Date: 03-Oct-2025
Our Ref: 2025/91054

**Discharge of details reserved by condition 23 (secure cycle parking) on previous permission 2023/92749 for variation of condition 2 (plans and specifications) on previous permission 2020/94096 for erection of 21 dwellings and associated works land south of, Swallow Lane, Golcar, Huddersfield, HD7 4NB
Application Number: 2025/91054**

Condition 23 (Secure cycle parking)

location STANDARD DETAILS			
title Bike Rack - Fence Mounted			
scale 1:20	drawn by JHY	date MAR 2025	
drawing no. JHY-SDL-0005		rev -

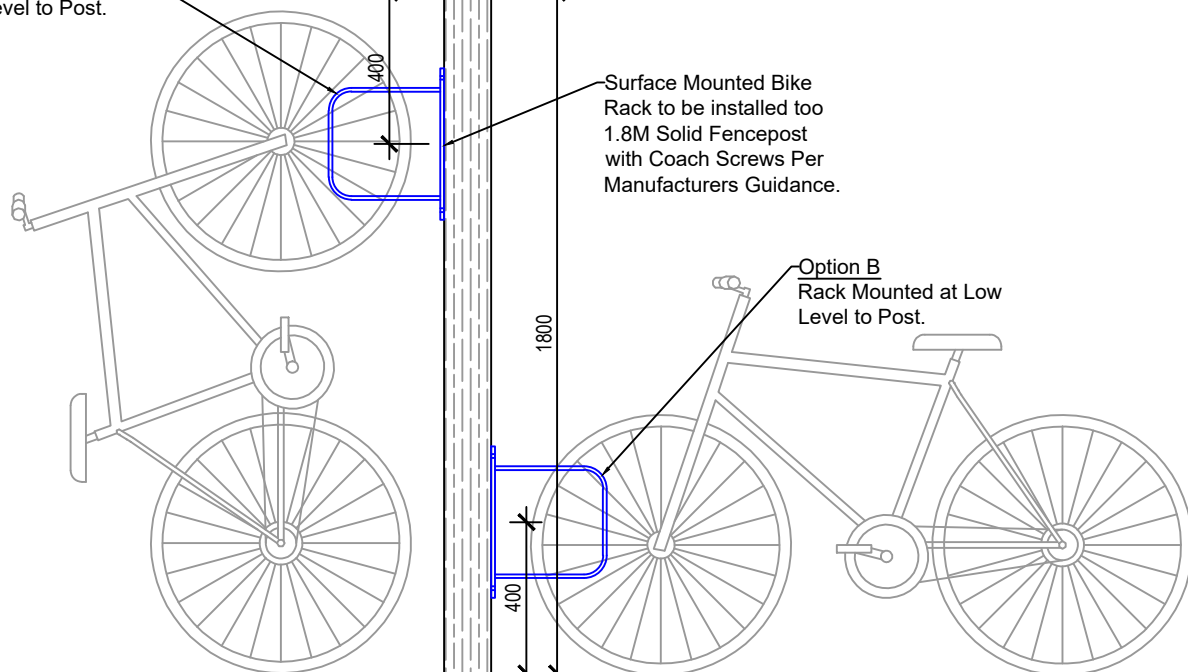
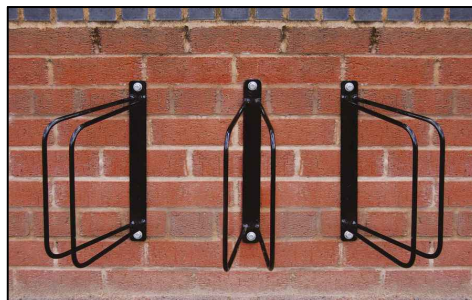
The proposed installation of fence mounted bike racks for those dwellings without a garage is not considered acceptable.

The medium or long-term storage of bikes via an external rack would not protect the bike from the elements, which will lead to damage and deterioration of the bike (particularly if an electric bike). Furthermore, the proposed rack would have limited crime mitigation value, with the degree of protection limited to a chain or similar.

Due to the above, it is concluded that the rack would not provide a convenient or welcoming means of storing a bike and therefore would not achieve the condition's objective of encouraging travel by alternative means.

For the avoidance of doubt, the submitted details are refused.
